PLANNING APPLICATION REPORT**REF NO:** FP/217/08/**LOCATION:** 4 Felpham Road
Bognor Regis**PROPOSAL:** Conversion and change of use of existing residential care home to 4 no private flats (Resubmission of FP/99/08)**SITE AND SURROUNDINGS**

PROPOSED GROUND FLOOR PLAN

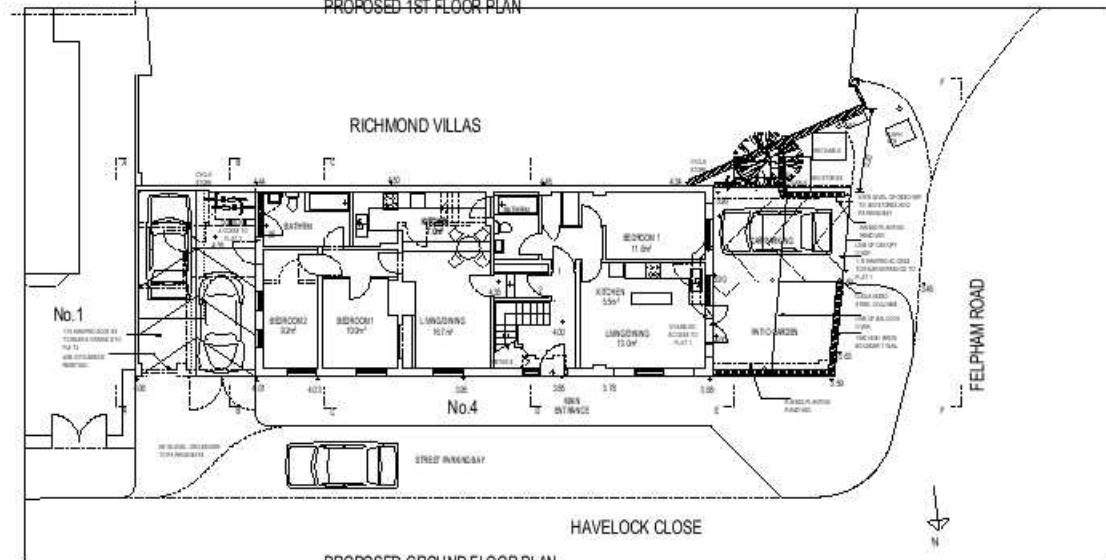
County Highways : Objection on the grounds that the property has insufficient frontage for vehicles to park without overhanging the public footway. Turning space is not sufficient to allow a vehicle to turn and enter the highway in the forward gear. The rear access would also not be suitable for car parking, due to its limited size.

County Highways have raised an objection that there is insufficient frontage for vehicles to pass without overhanging the public footway and there is no turning space to allow a vehicle to turn and enter the highway in forward gear. Also the rear access would not be suitable for car parking due to the limited size.

- 1 Adequate provision cannot be made within the site for the parking of vehicles in a satisfactory manner to the standard required by the Local Planning Authority in conflict with policies NE17, DEV5 of the West Sussex Structure Plan and GEN7, GEN12 of the Arun District Local Plan.

Drawing PROPOSED ELEVATIONS, SECTIONS	Scale 1:100	Date OCT 08	Drawing No. 9270/PL2/04
---	----------------	----------------	----------------------------

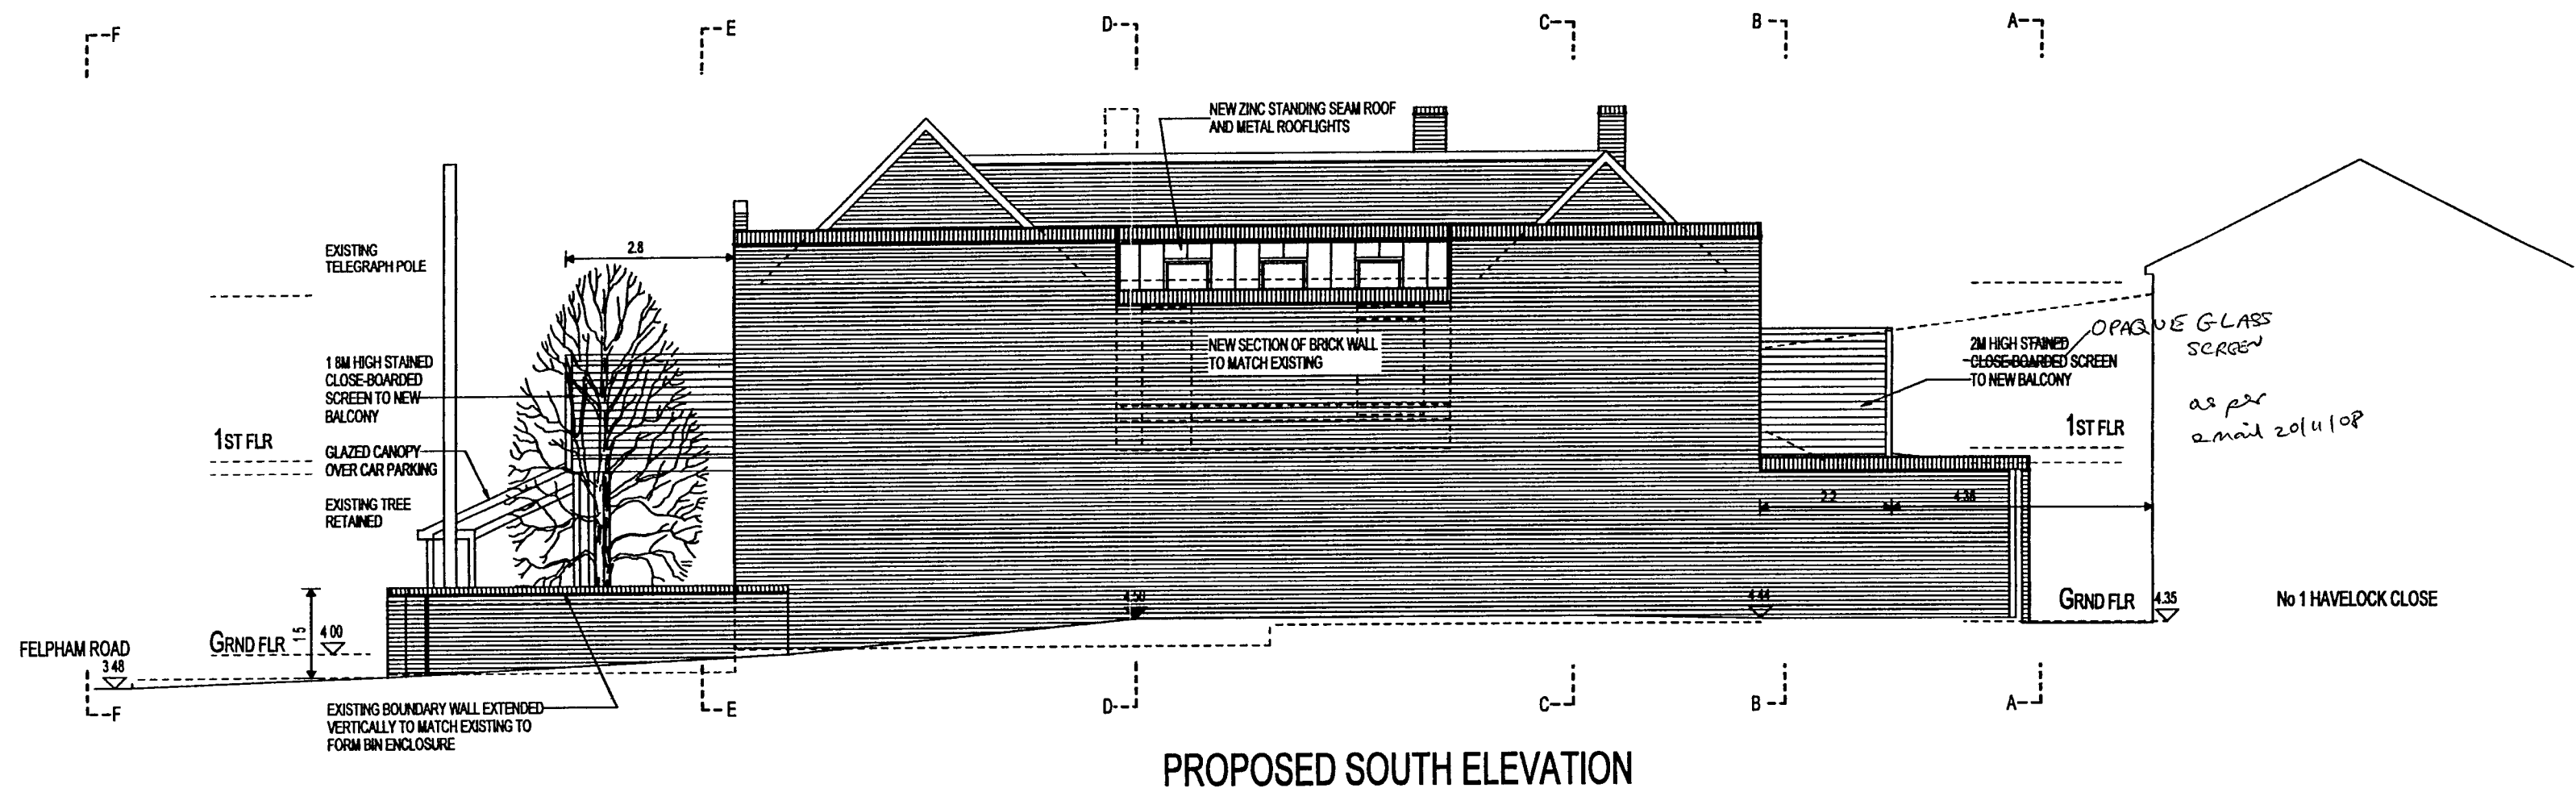
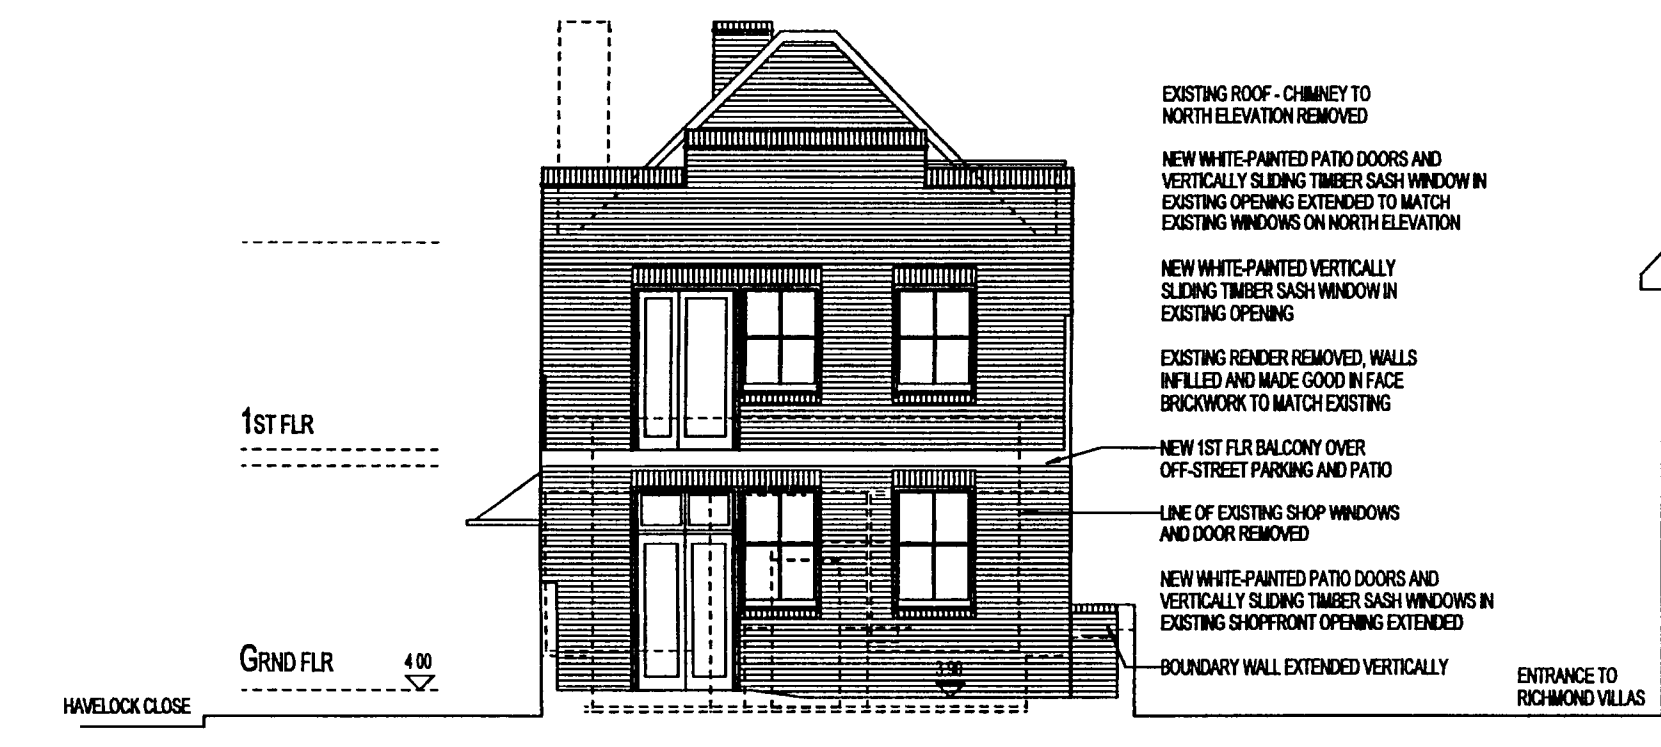
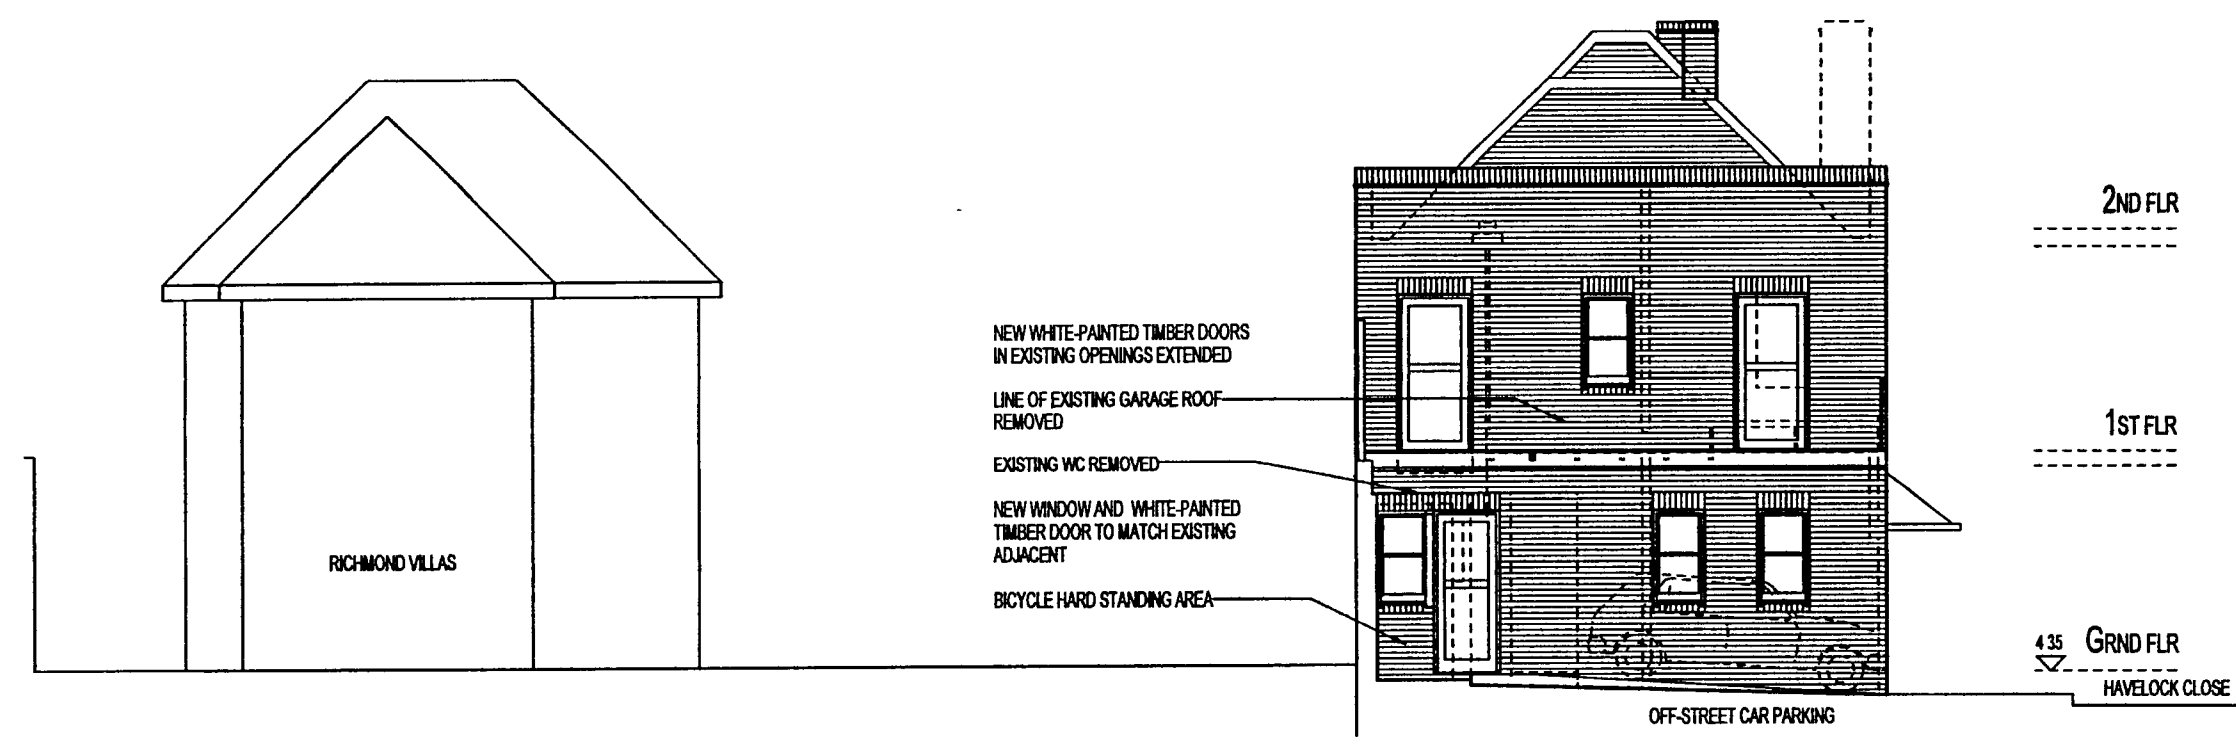
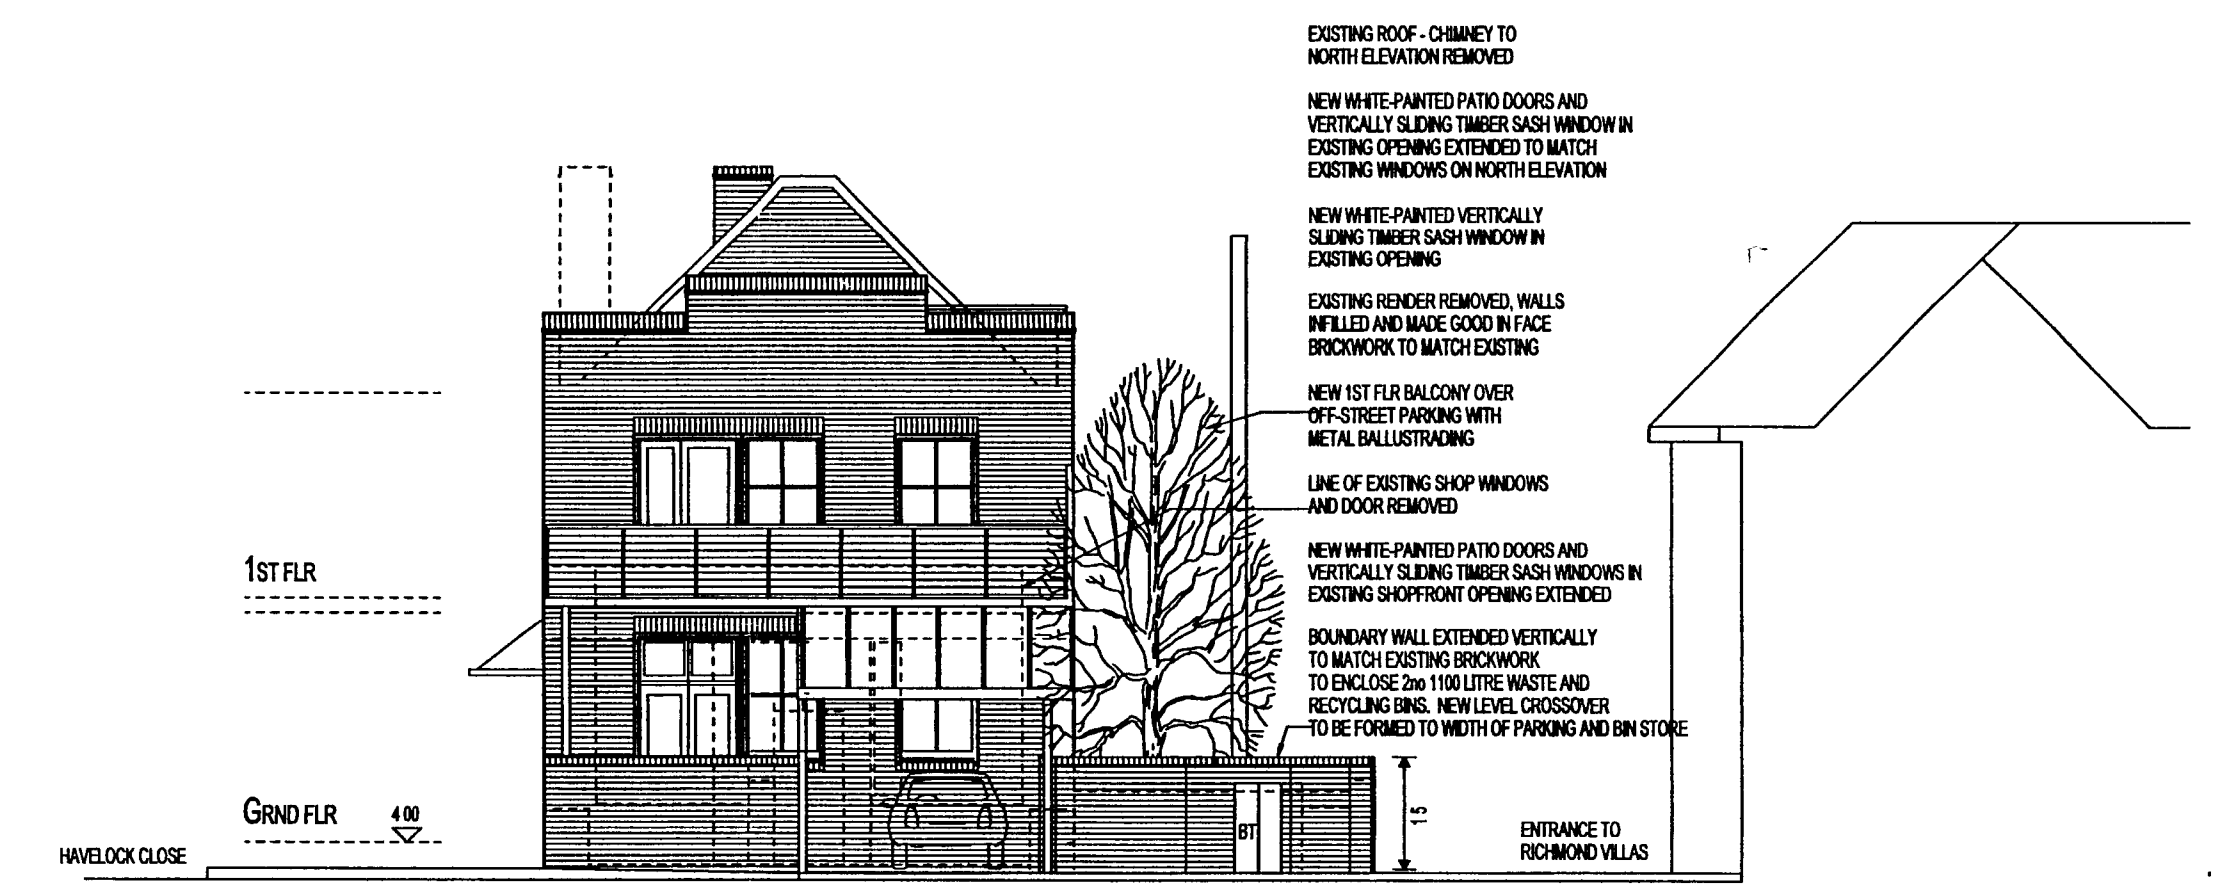
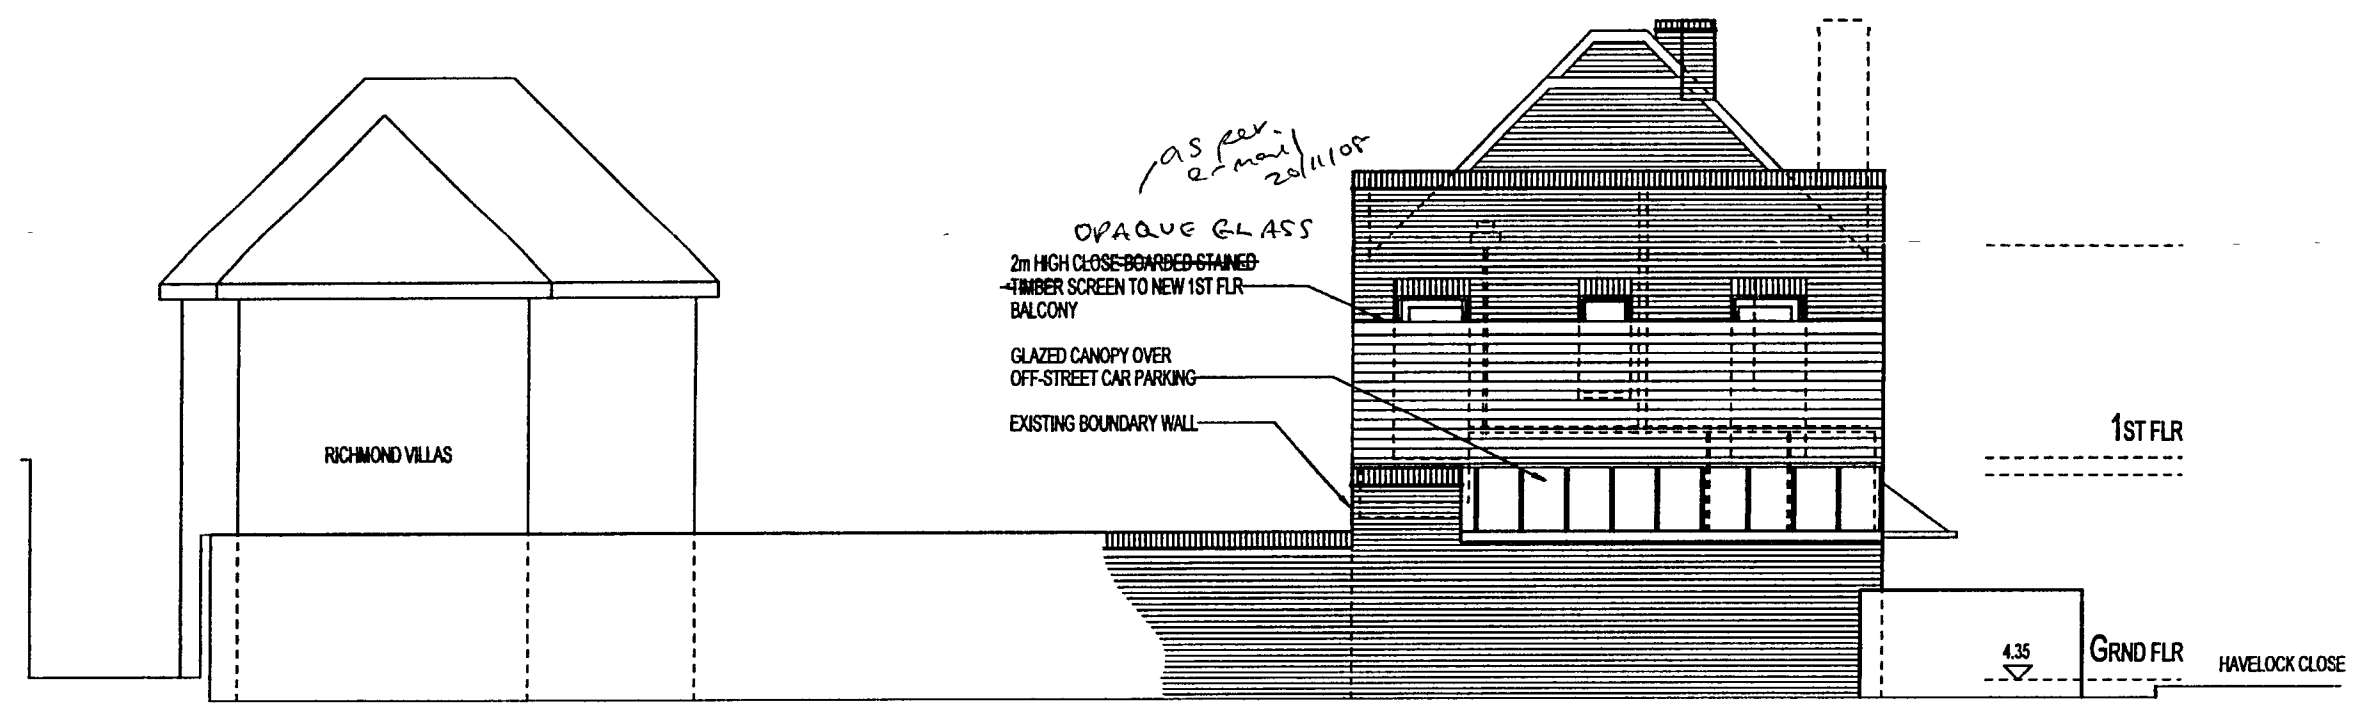
One letter of objection : the residents of Havelock Close have not been consulted. The proposed lean to over the first floor bedroom will directly face neighbouring windows. Will external lights be affixed? Parking is a problem and insufficient parking is proposed. Cannot read plans on the website very well.

The south elevation is the rear elevation which fronts onto the car park area of the adjacent flats. The proposal is to raise the parapet wall 2.6m and to introduce high level glazing. The fenced enclosed balcony 2m high is the only other alteration on this elevation.

The east elevation introduces a 2m fence over a balcony with minor changes to fenestration and glazing over the side of the carport.

The changes that could potentially adversely affect the residential amenity of neighbouring properties is the use of the proposed balconies. However, these are being screened with 2m high opaque glass screens which will be permanently fixed. Therefore there is no potential for overlooking neighbouring properties. The balcony to the front of the site only directly overlooks the river embankment and does not directly overlook any neighbours. However, as the front elevation is onto a busy public road, it is considered that a balcony of 2.2metres is too large in depth, particularly as this is accessed from a principal room.

The first floor balcony is screened with 2m high opaque glazing and therefore there can be no direct overlooking of neighbouring properties. It could be conditioned that there is no external lighting. An orange site notice was posted on the lamp post outside the site, neighbour notification is not a policy of this Authority.
